From: Bloomer, David <David.Bloomer@lancashire.gov.uk>
Sent: 27 July 2018 14:09
To: Robert Major
Cc: LHS Customer Service; planning
Subject: app3/2018/0555 3 Rivers Caravan Park

FLOOR PLAN AS PROPOSED

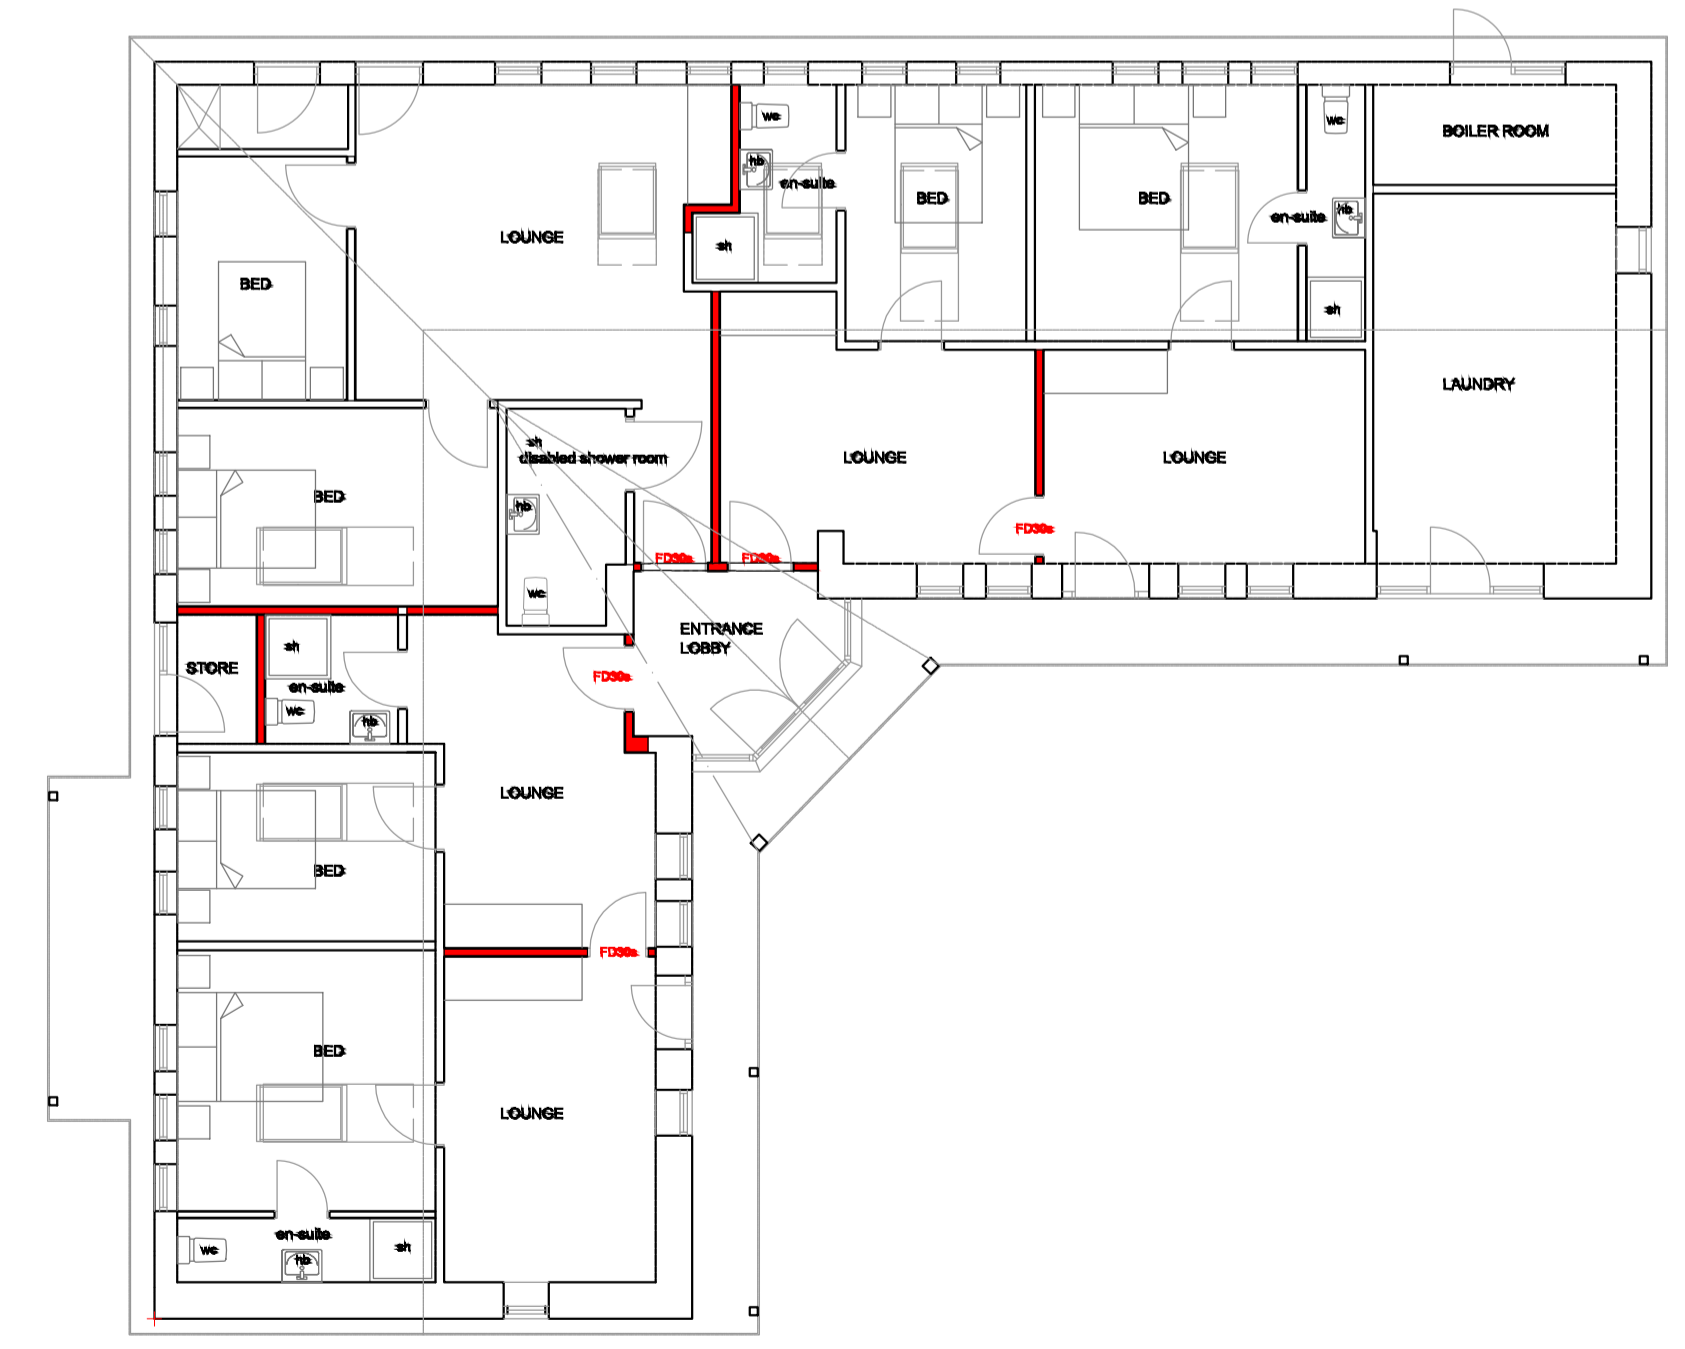
The proposal raises no highway concerns and I would therefore raise no objection to the proposal on highway grounds , however looking at the submitted layout the applicant may wish to consider providing a continuous footway link between the proposed parking and the entrance to the building.
